MODIFICATION TO SSD 7662 (MOD 3 Submission)

Approved Section: 4.55(1A) Application No: SSD-7662-Mod-3

project:
SOP 53
2 FIGTREE DRIVE
SYDNEY OLYMPIC PARK

title:
**GENERAL ARRANGEMENT
PLAN - LEVEL B01**

PLAN - LEVEL 16

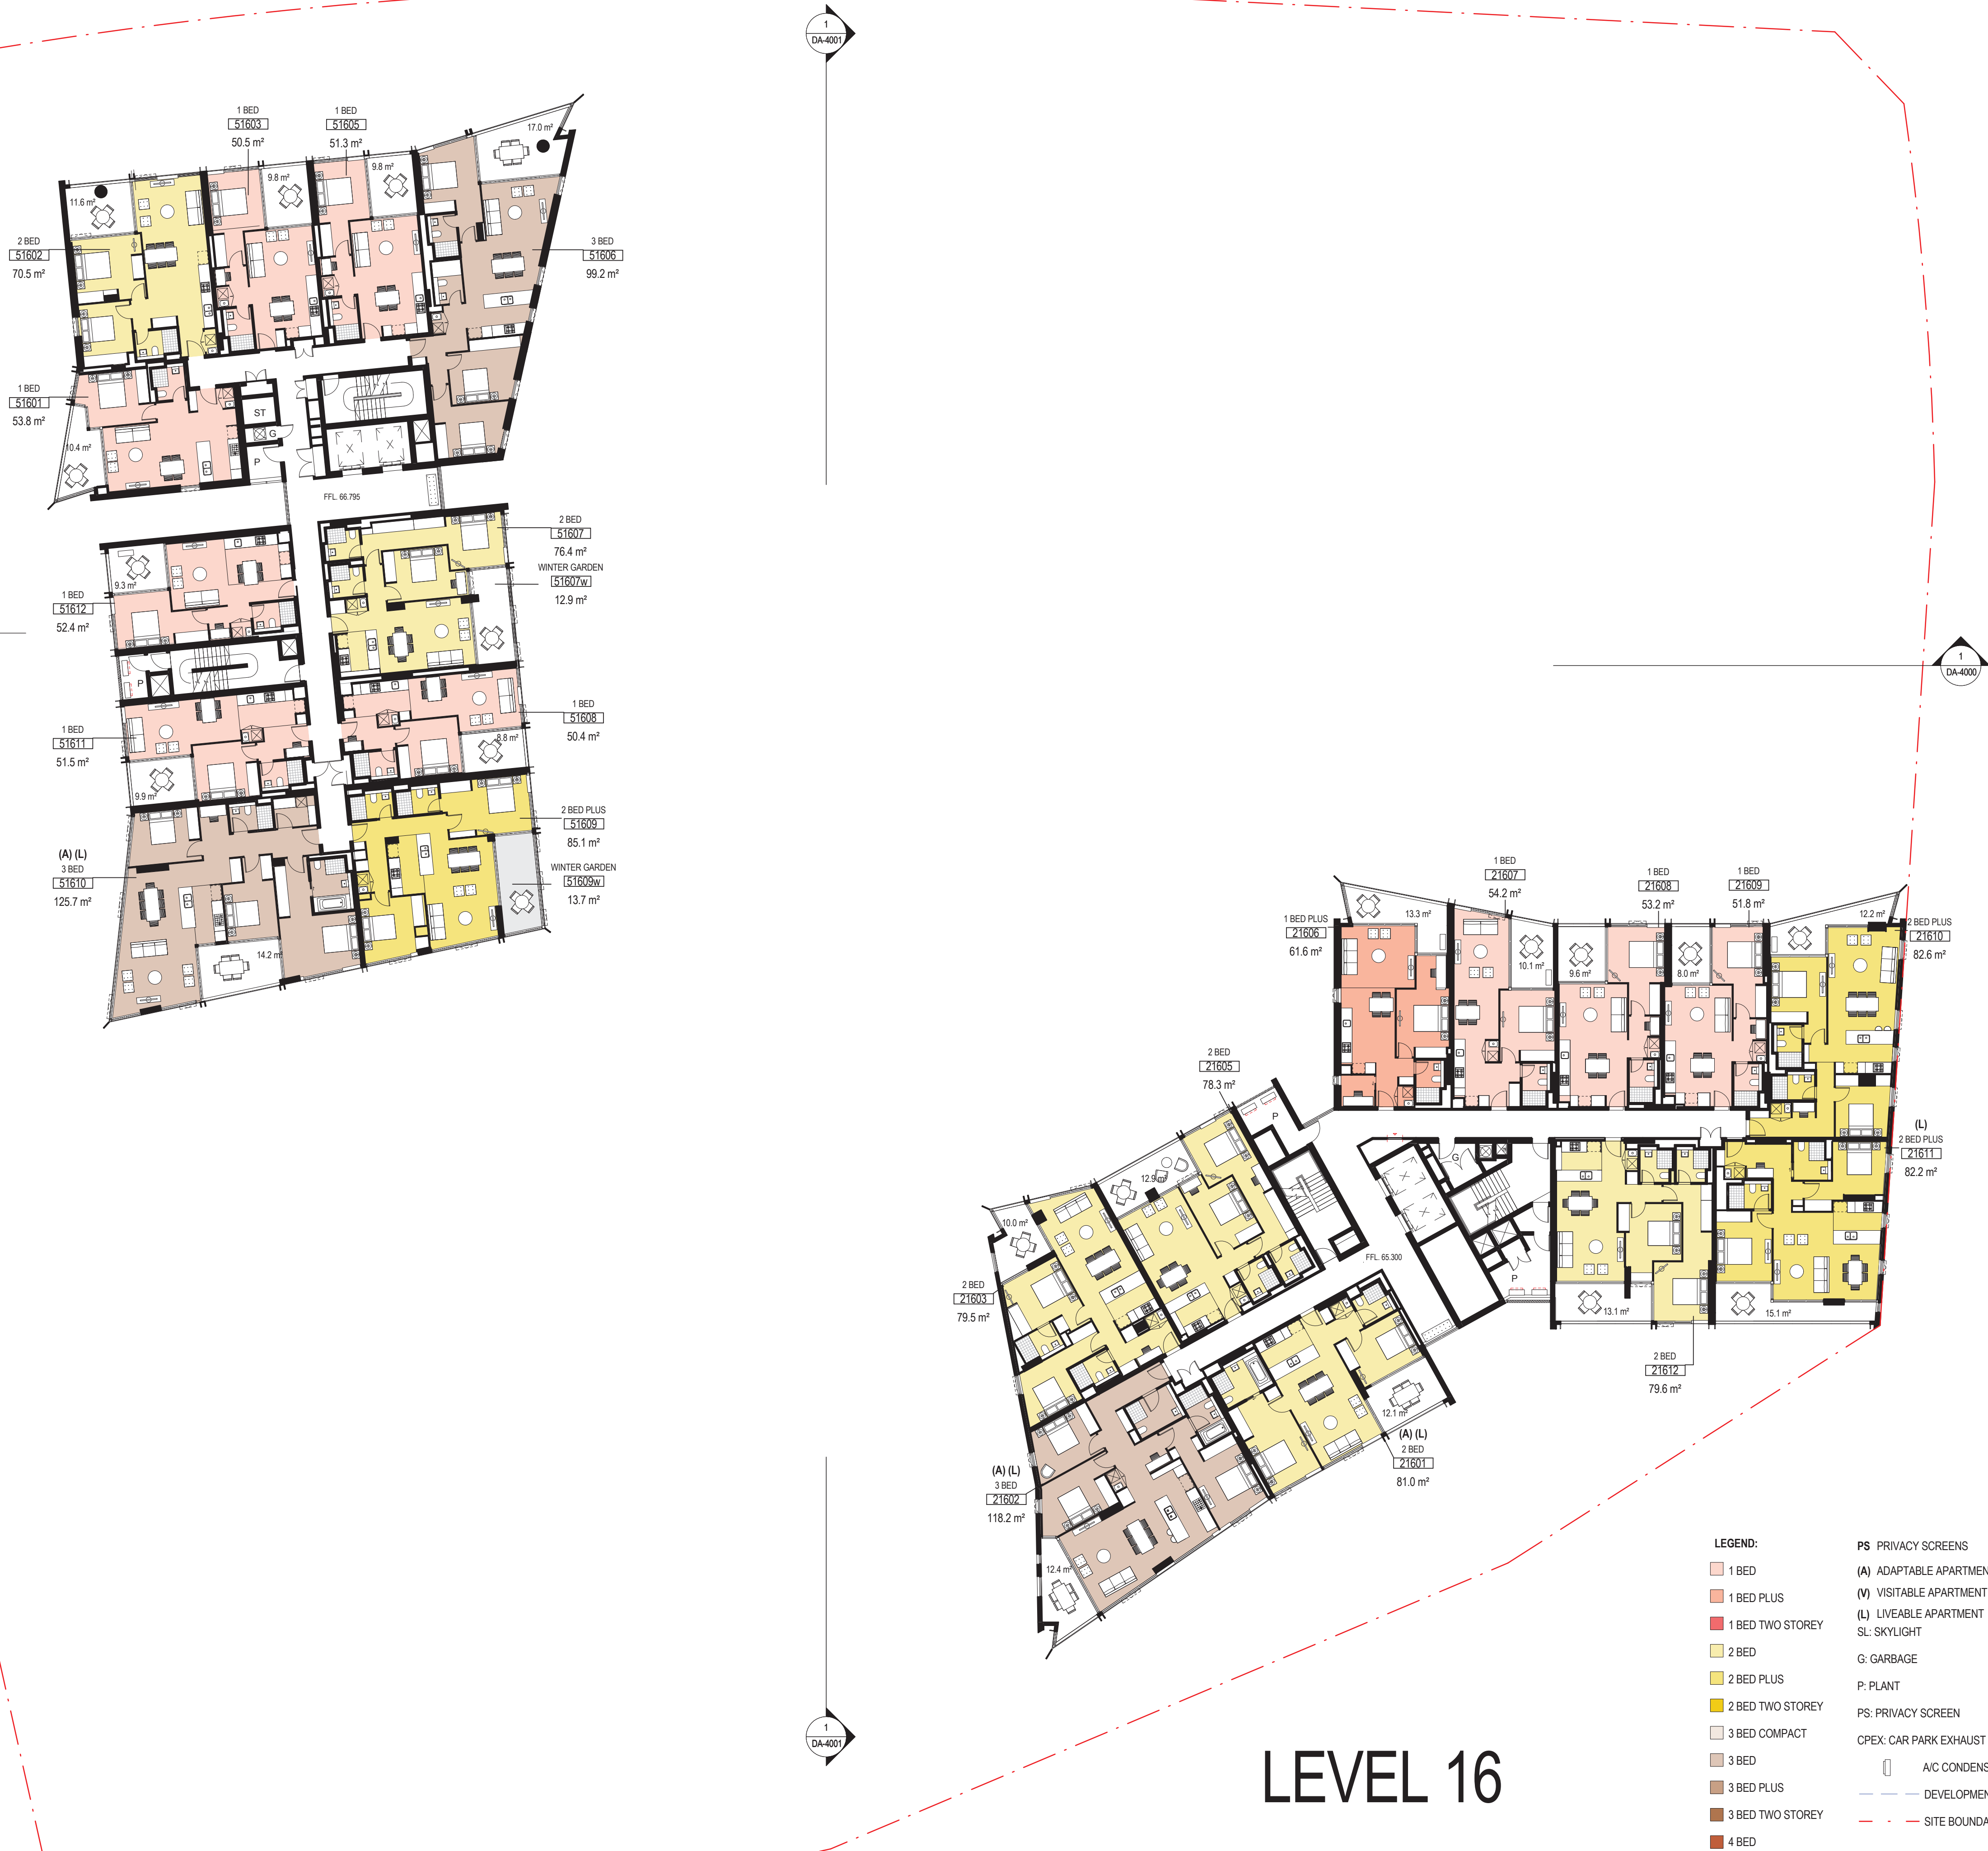
BUILDING 2
2a. Conversion of 10 x 2 Bed apartments into 1 Bed + Study apartments (Level 12 to 21)
2b. Deletion of window in bedroom in Apt 22303 & 22403
2c. Roof plant screen amended to suit services plants layout on Level 25

**GENERAL ARRANGEMENT
PLAN - LEVEL 24**

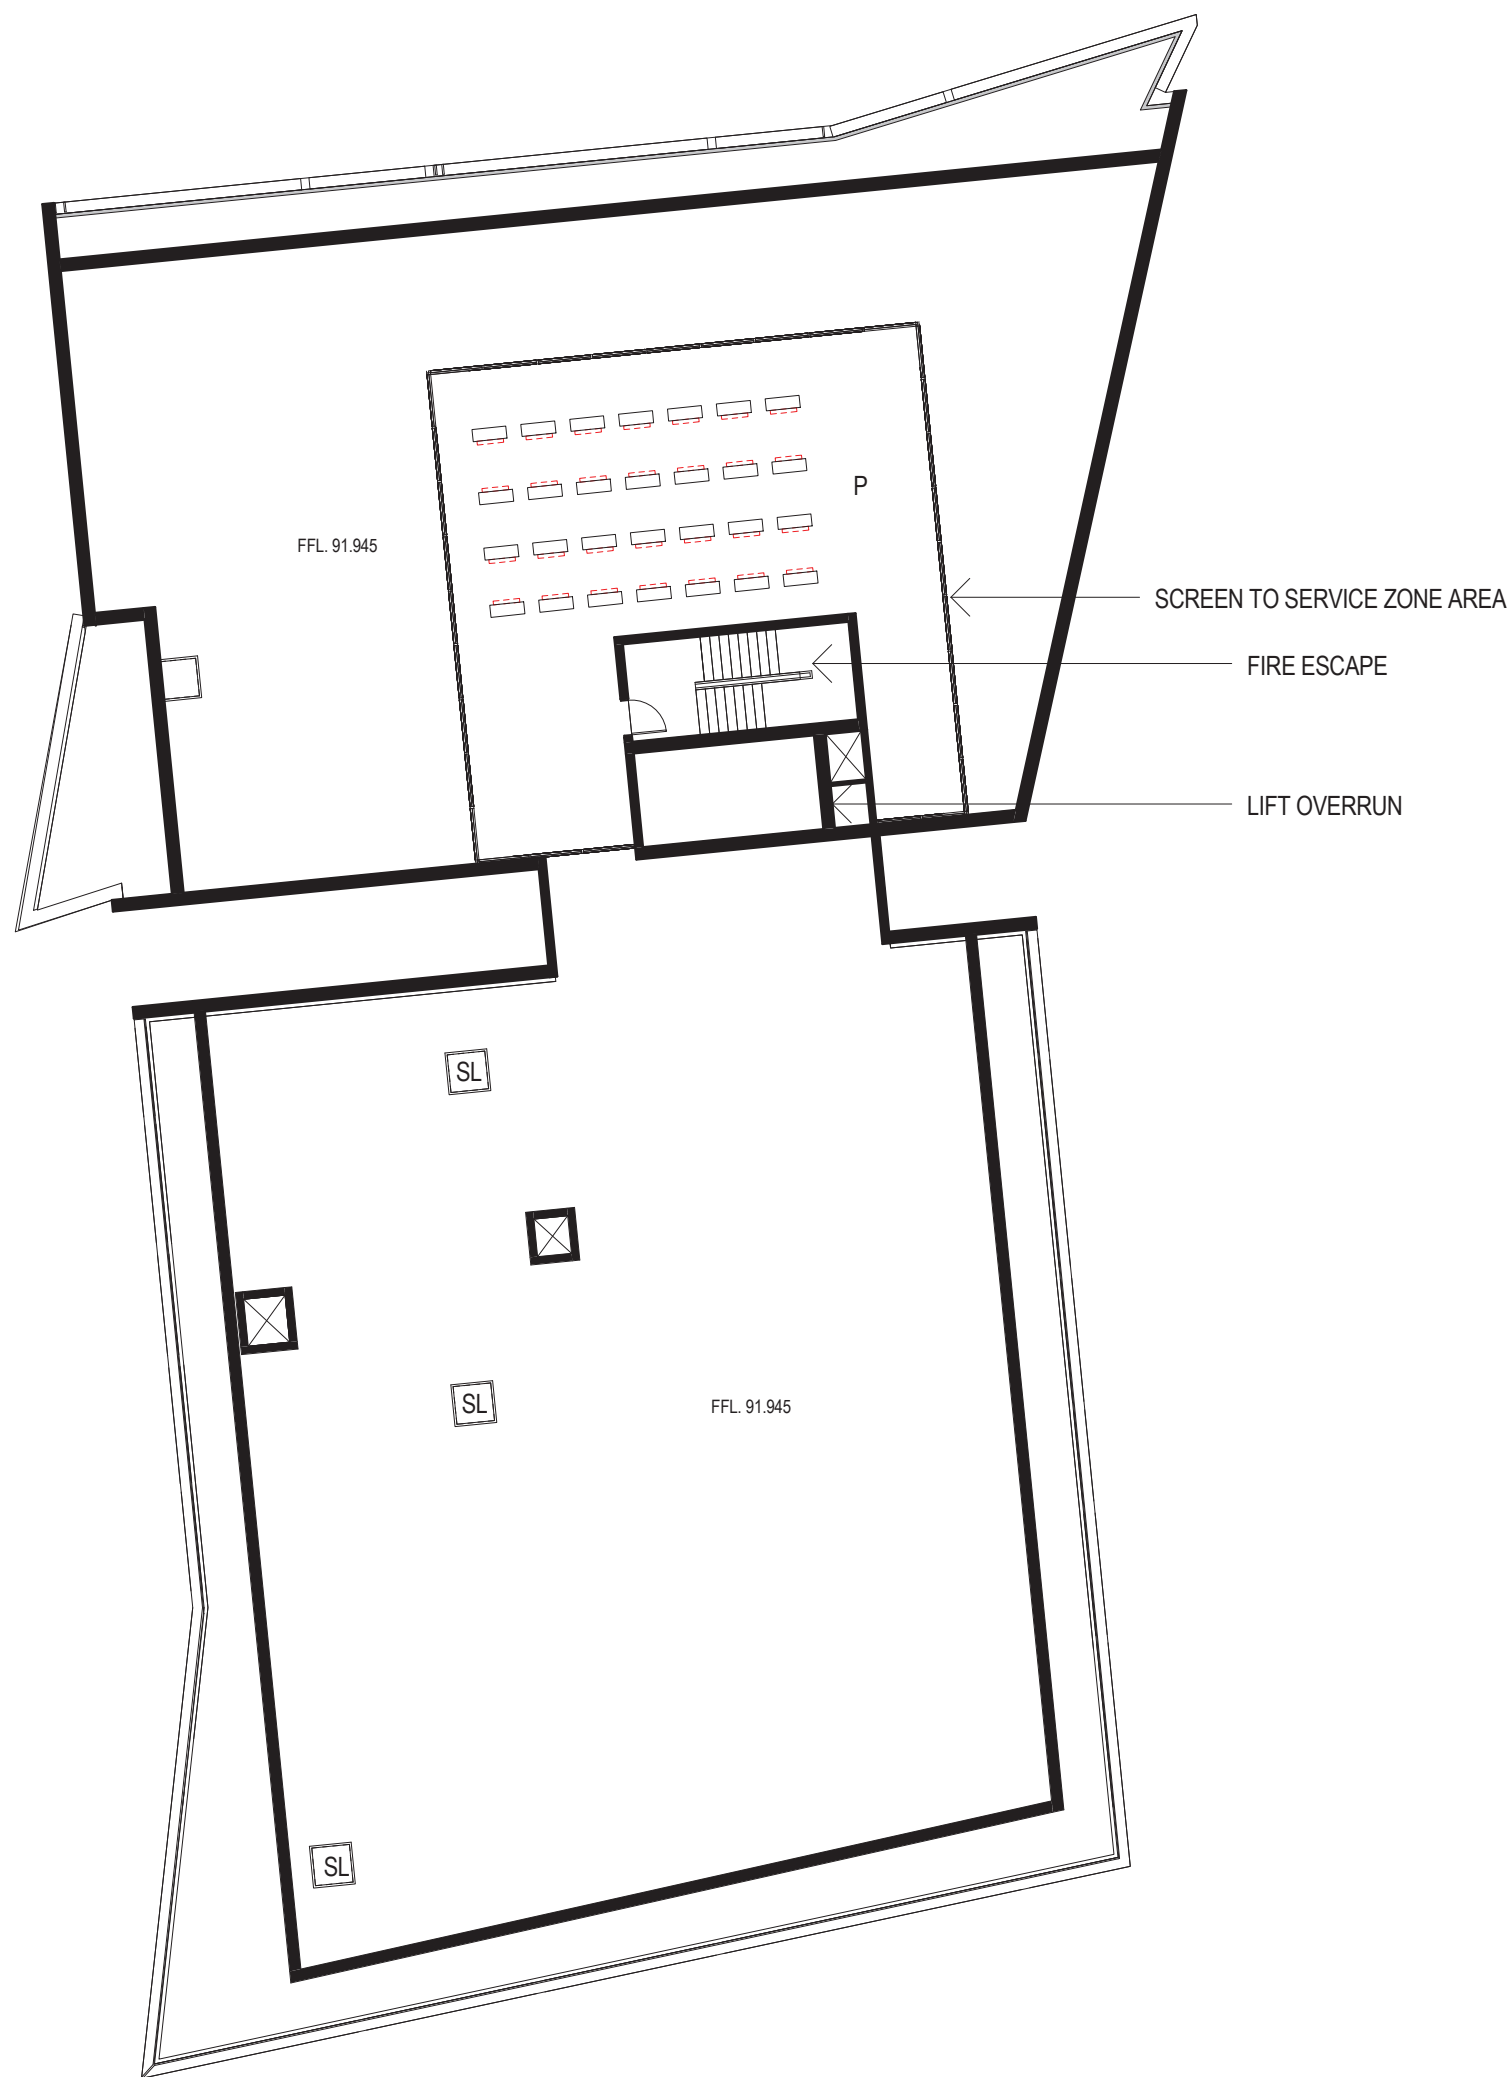
BUILDING 5
5a. Deletion of window in balcony in Apt 52305
5b. Roof plant screen on Level 24 reduced
